TRIPLE A HOMES			
SCOPE	CHANGE TO JOIST SUPPORT LOCATION; SHED RAFTERS	REV #	REF PROJ #
LOC	120 SERENITY	DATE

ENG: RJS
DATE: 9-7-2023

PARENT
23-28-011

PROJECT NO.
23-75-861

ROOF FRAMING PLAN
 1/8" = 1'-0"

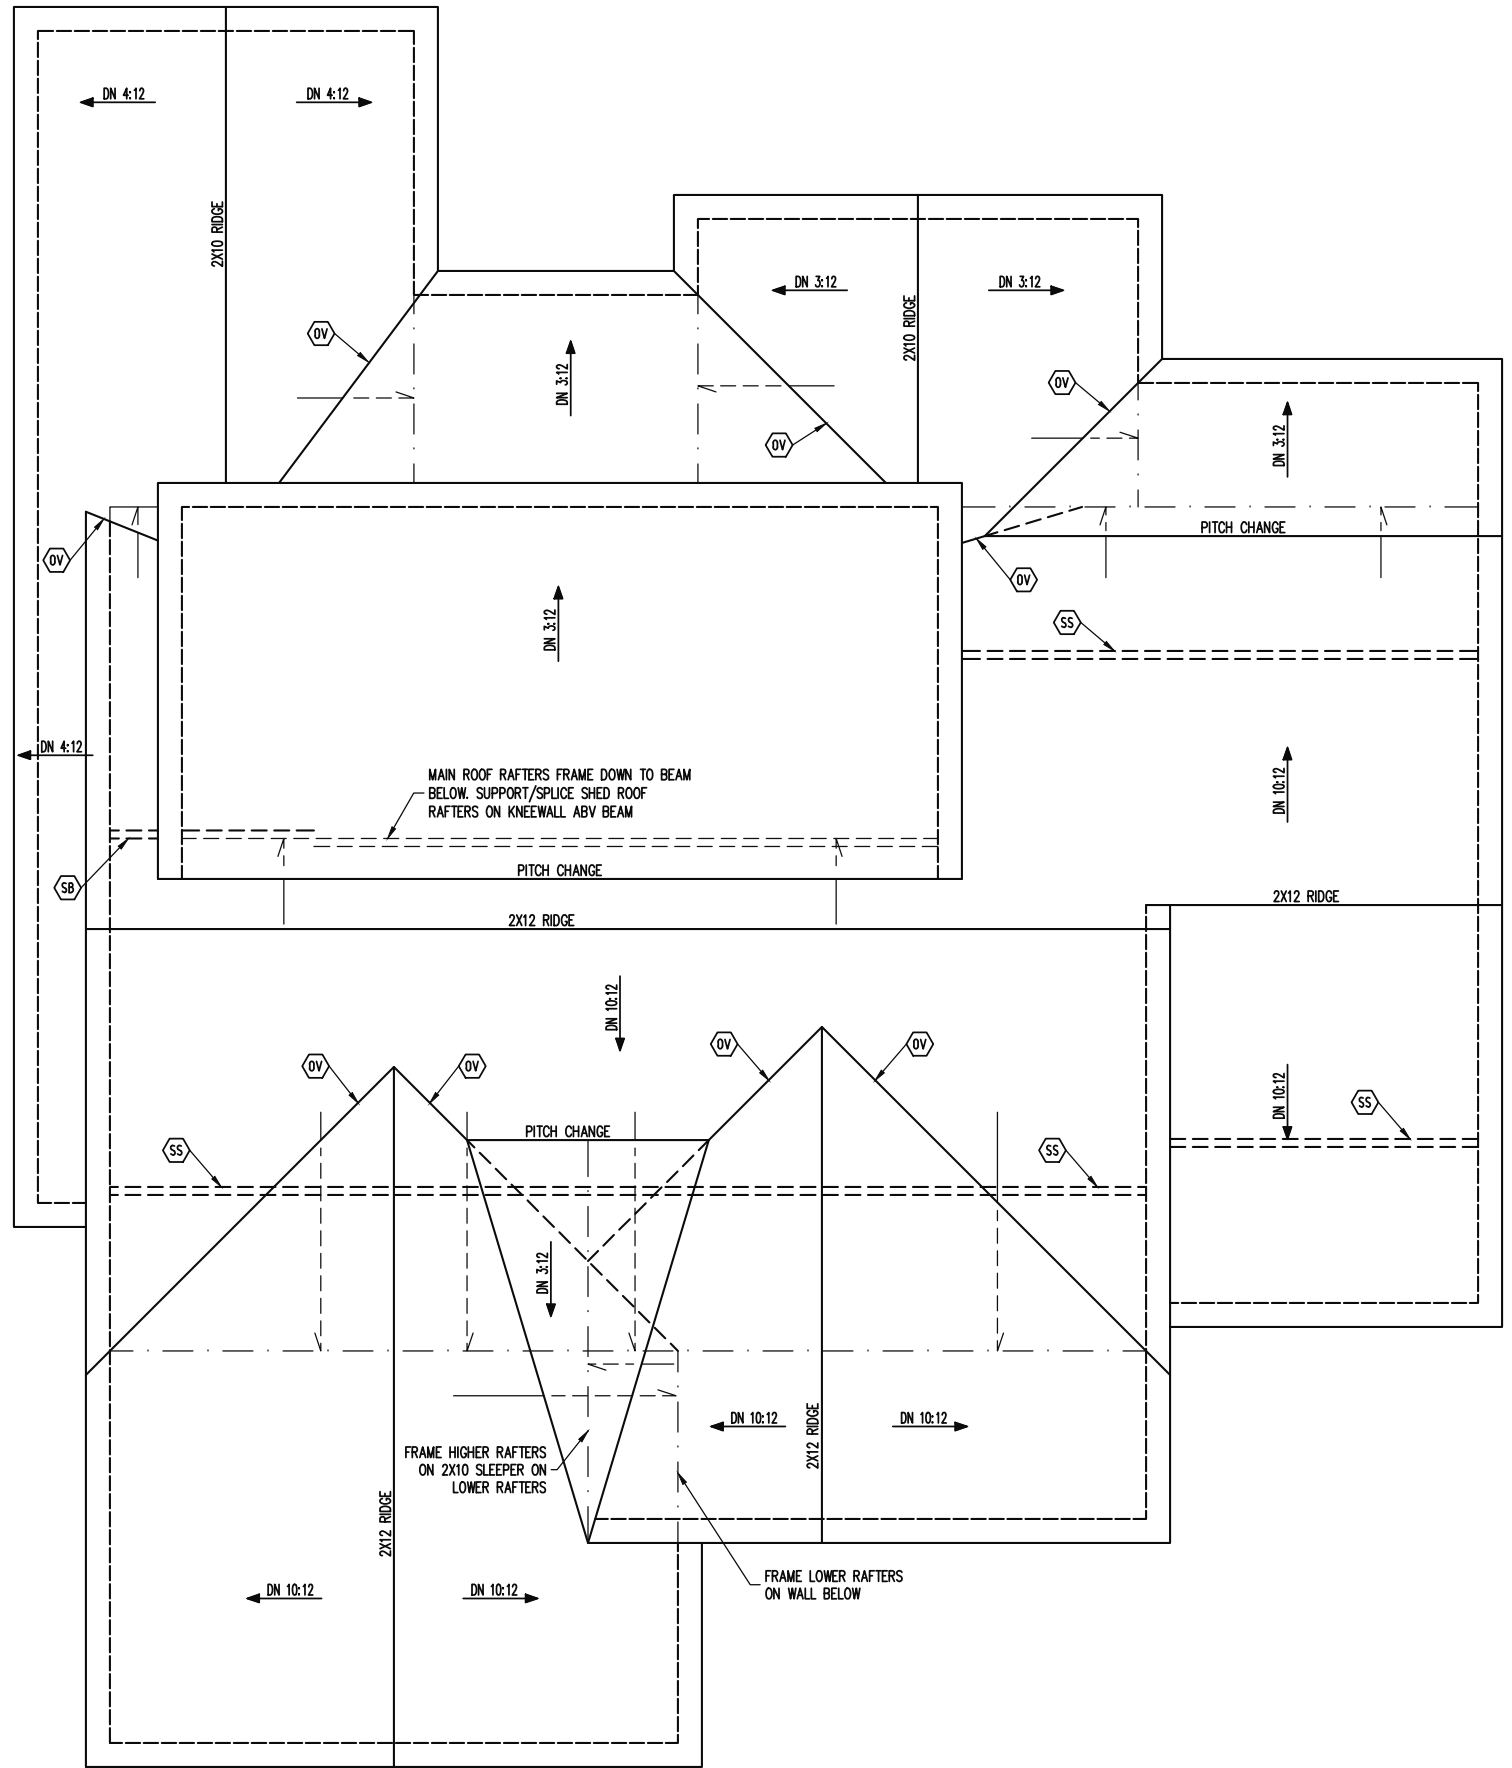
MAIN ROOF RAFTERS FRAME ON KNEEWALL ON BEAM BELOW. SHED RAFTERS FRAME ON PLATE ABOVE RAFTERS. NO ADDITIONAL KNEEWALL TO SHED RAFTERS REQUIRED. INSTALL 2X4 TIEBACKS @ 16" O.C. FROM MAIN RAFTERS TO CEILING JOISTS PER ORIGINAL 9/S4.
